Planning applications no: 3/2014/0558 – 0562 (5 number).

Proposal: Phases 1 – 5 of proposed dairy unit. Steel Portal framed agricultural buildings providing housing for a total of 140 cows in cubicles.

Location: Demesne Farm, Settle Road Newsholme.

Title: Proposed Site Plan of Phase 4 of
Agricultural Building.

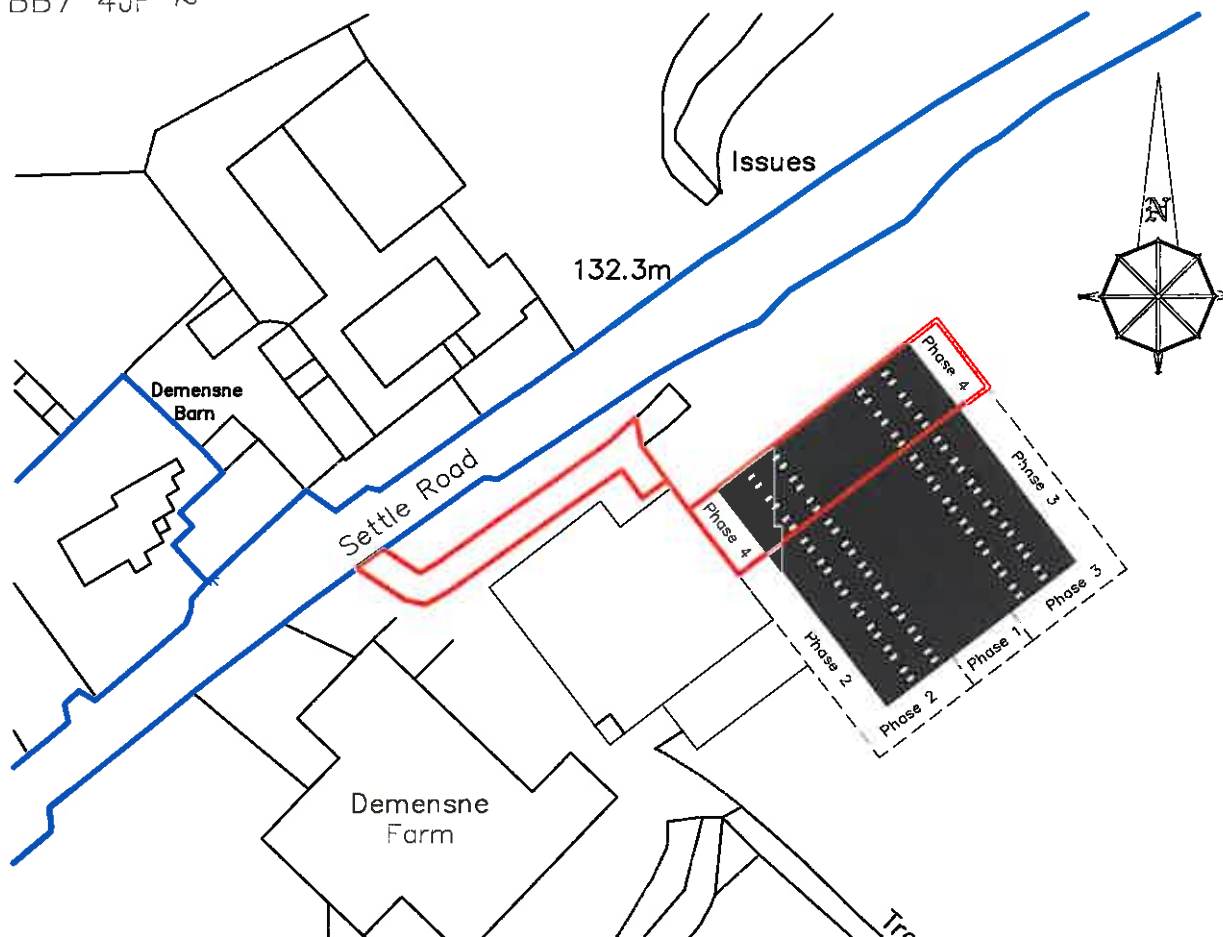
The access to be used for this expanded operation is the existing gated farm access directly off A682. The gate is set at the edge of the highway and about 0.5m from the edge of the carriageway. The visibility along A682 from this access is poor.

The access width should be increased to 6m to allow two vehicles to pass each other, thereby avoiding a situation where a vehicle waits on the highway until another vehicle drives out. The gate should be set back 10m from the edge of the carriageway. In addition there should be sufficient space within the site for all vehicles to be able to turn around and drive out in forward gear.

Unless the developer can show that the other nearby vehicle accesses off the northern side of the A682 are required, I would ask that these are closed up. There are three in total within 120m and to the west of the proposed access.

The visibility along the A682 should be improved to the extent that this is possible by cutting back vegetation and moving hedges, lowering or moving walls and moving the 'Buck Inn' sign. The visibility should be 2.4m by 190m here although I am asking for an improvement as described above in this paragraph.
